Charlotte Department of Transportation

Memorandum

Date: April 30, 2008

Subject: Rezoning Petition 08-082: Located on the east side of Matheson Avenue between North Tryon Street and the Southern Railway railroad

MATHESON AVENUE/30th STREET
 COLLEGE STREET EXT. AND DRIVEWAY ACCESS PLAN
 ILLUSTRATIVE SITE PLAN

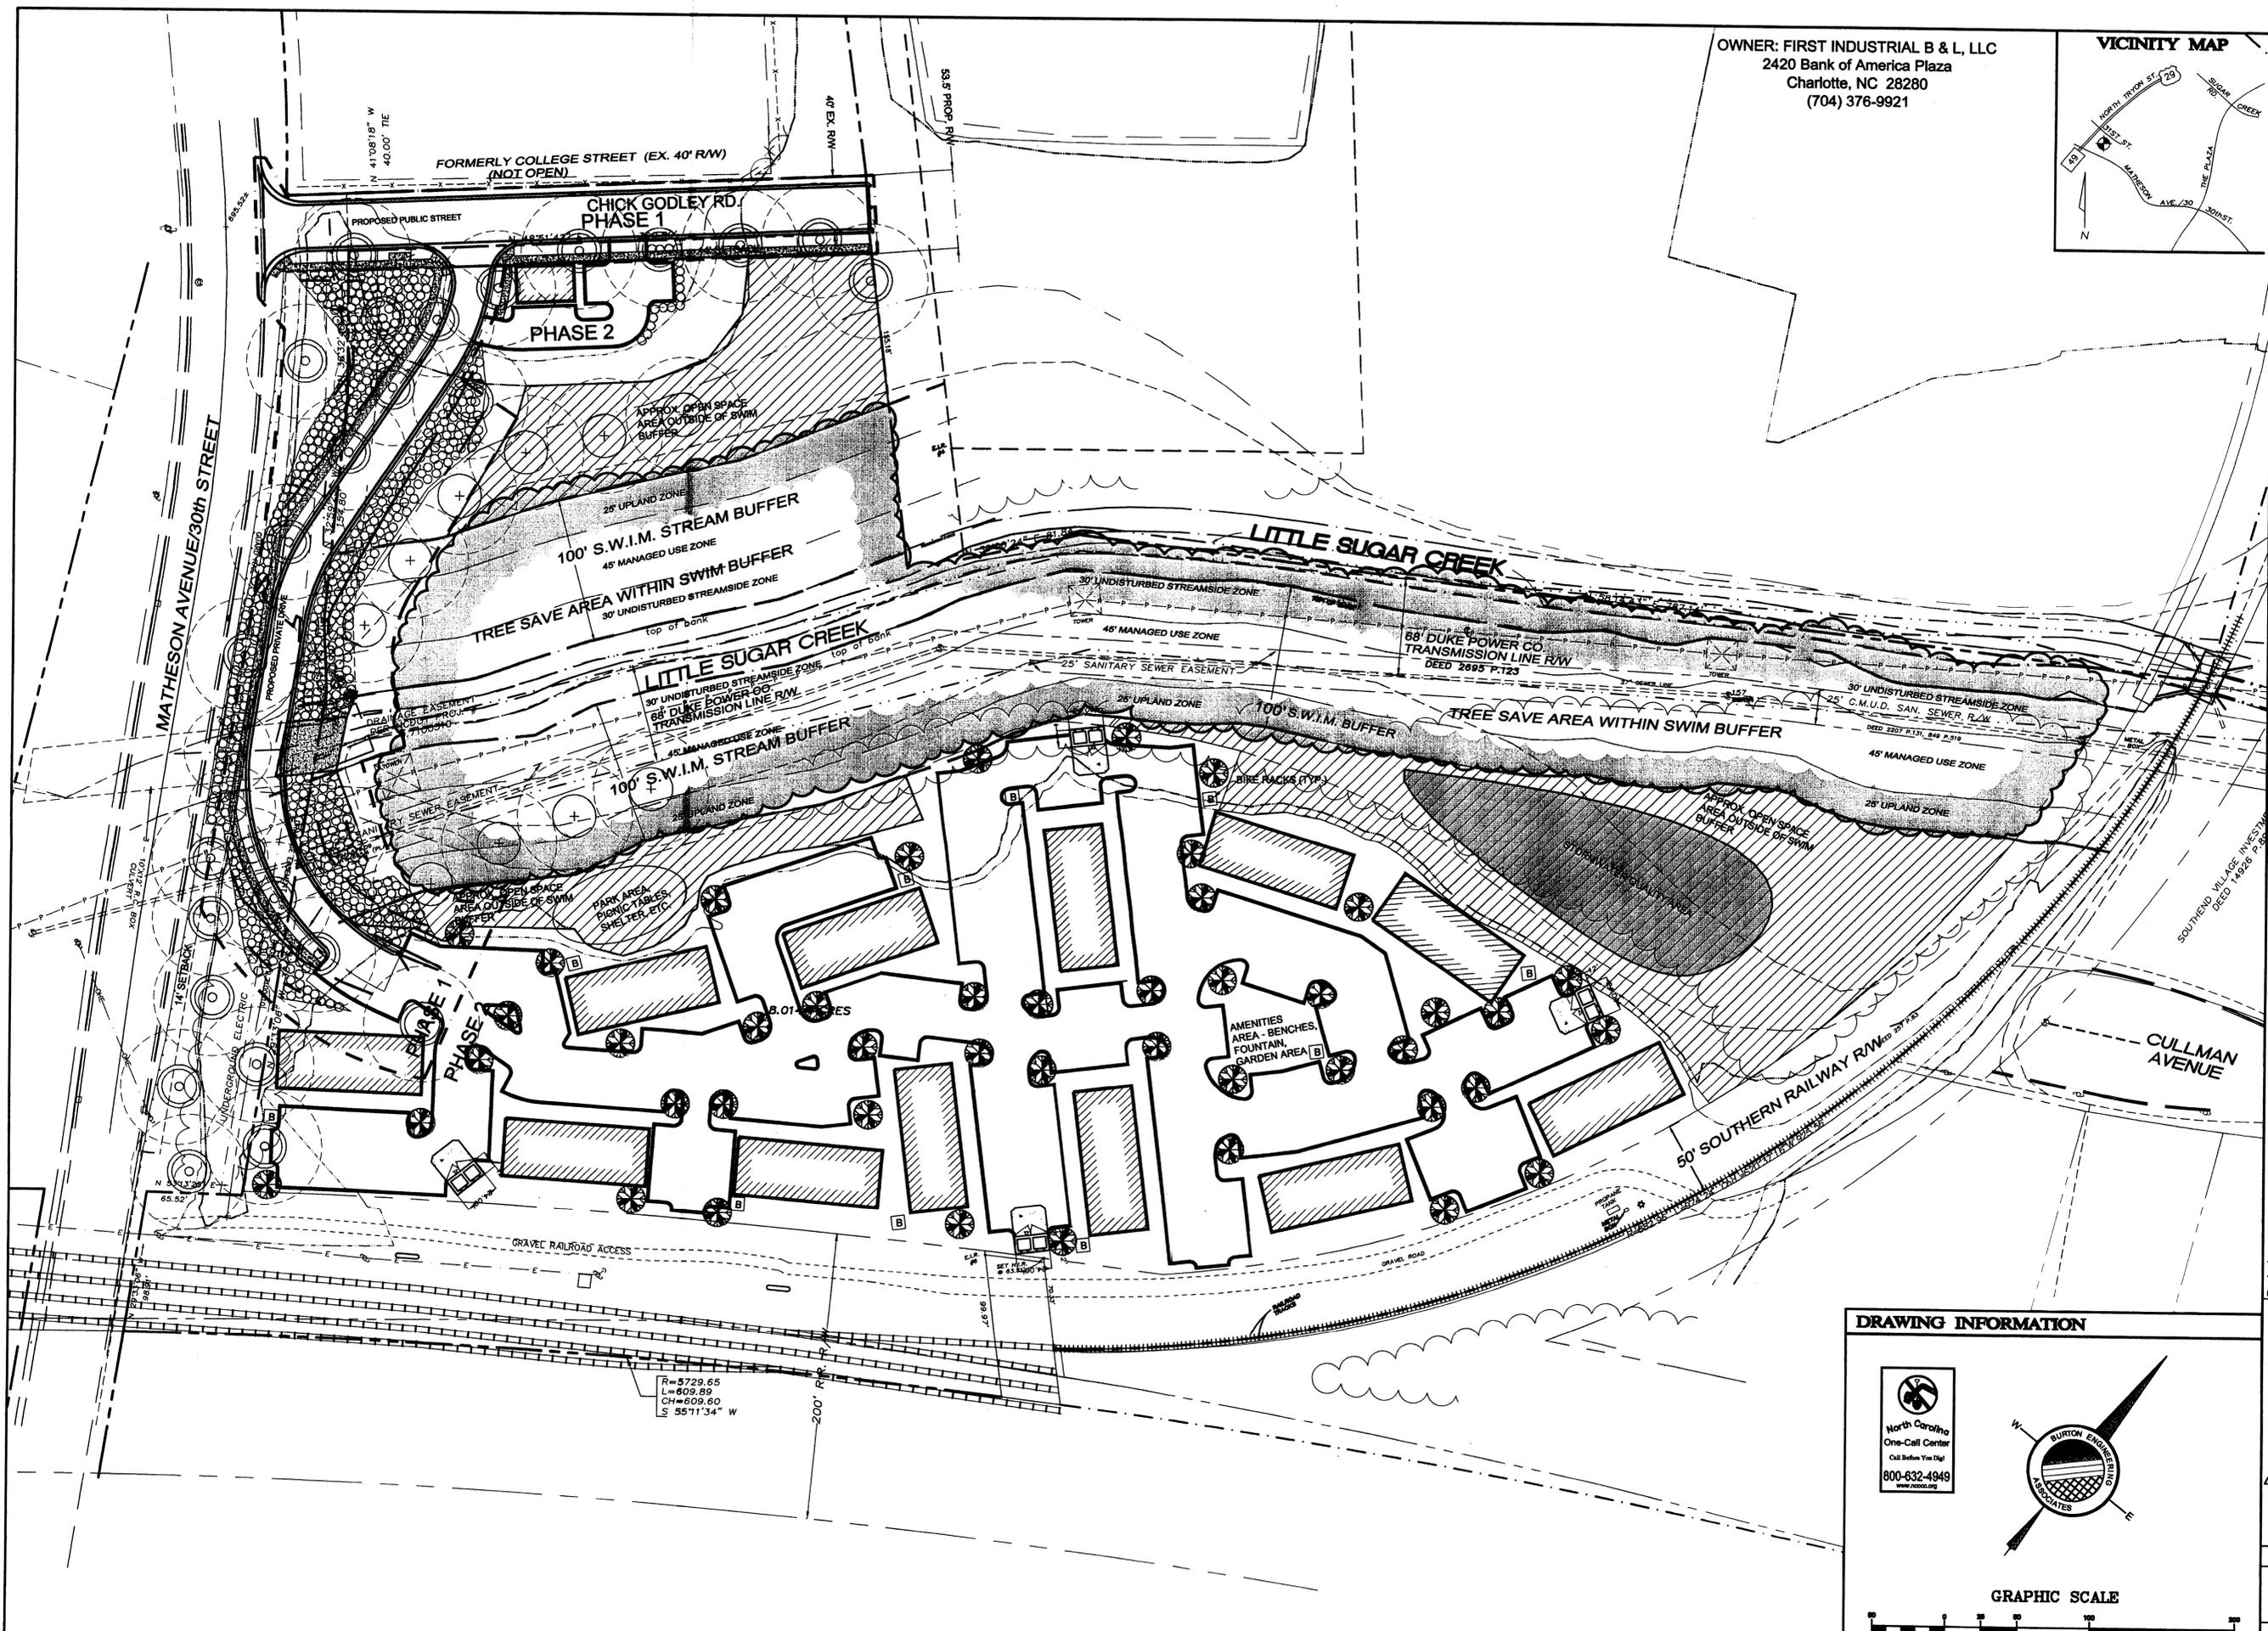
1. The developer must improve presently unopened College Street (proposed Chick Godley Drive) along the entire frontage of the site. This road needs to be designed as a Local Industrial Street with a cross-section of 35 feet (back-of-curbs), 8-foot planting strips, and 6-foot sidewalks (wider sidewalk per UR zoning) in accordance with the adopted *Urban Street Design Guidelines* (USDG).
2. The petitioner needs to secure the necessary easements to maintain and pave the existing non-motorized path connection from the site to Cullman Avenue via an at-grade railroad crossing and adjoining property.

3. The developer needs to design and construct vertical pedestrian circulation from the new street going through the site to the bridge deck of Matheson Avenue. This is necessary to provide more route choices, including resident pedestrian access to the planned 27th Street light rail station on the LYNX Blue Line extension to Northeast Charlotte.
4. The revised site plan needs to more clearly indicate the parcel boundary and the centerlines of the adjacent open and unopened right-of-ways.

1. The site plan needs to show better pedestrian connectivity among buildings and throughout the site. We recommend that the "Proposed Access" actually serve as a street, following the design guidance of a Local Residential Street – Wide (USDG). Such street has a cross-section of 35 feet (back-of-curbs), 8-foot planting strips, and 6-foot sidewalks. This request will create a more pedestrian-scaled development rather than one that is generally oriented around a large surface parking lot.

Adequate sight triangles must be reserved at the proposed street entrance. Two 35' x 35' sight triangles are required for the entrance to meet requirements. All proposed trees, berms, walls, fences, and/or identification signs must not interfere with sight distance at the entrance. Such items should be identified on the site plan.
